From: Sarah Burrow <Sarah.Burrow@arun.gov.uk>
Sent: 08 February 2022 10:35
To: Planning.Responses <Planning.Responses@arun.gov.uk>
Cc: Amber Willard <Amber.Willard@arun.gov.uk>
Subject: RE: Planning Consultation on: M/147/21/HH

Engineers Comments Regarding Surface Water Drainage

Application No: M/147/21/HH

Description of Works: Single storey rear extension and addition of a storey.

PROPOSED GROUND FLOOR PLAN

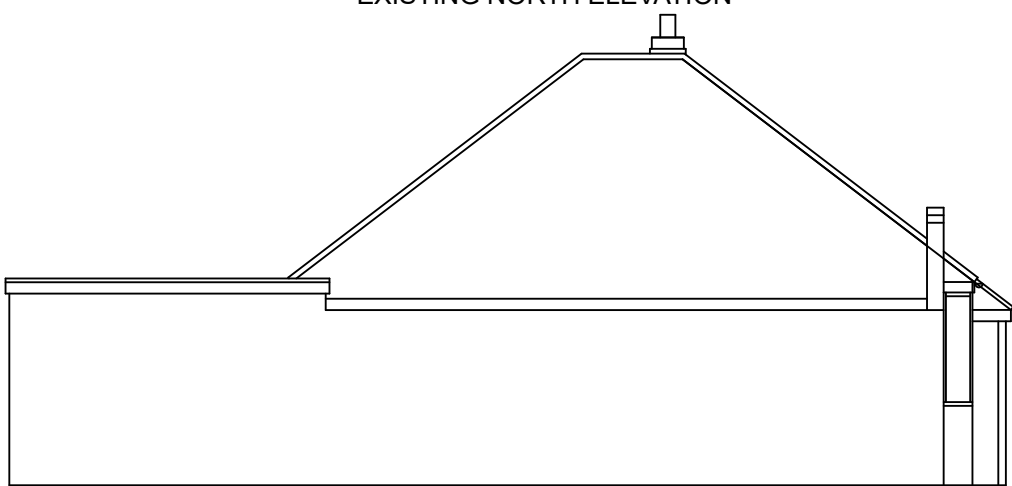
I recommend that the EA is consulted with regards to the FRA and proposal of a bedroom on the ground floor in Flood Zone 3a.
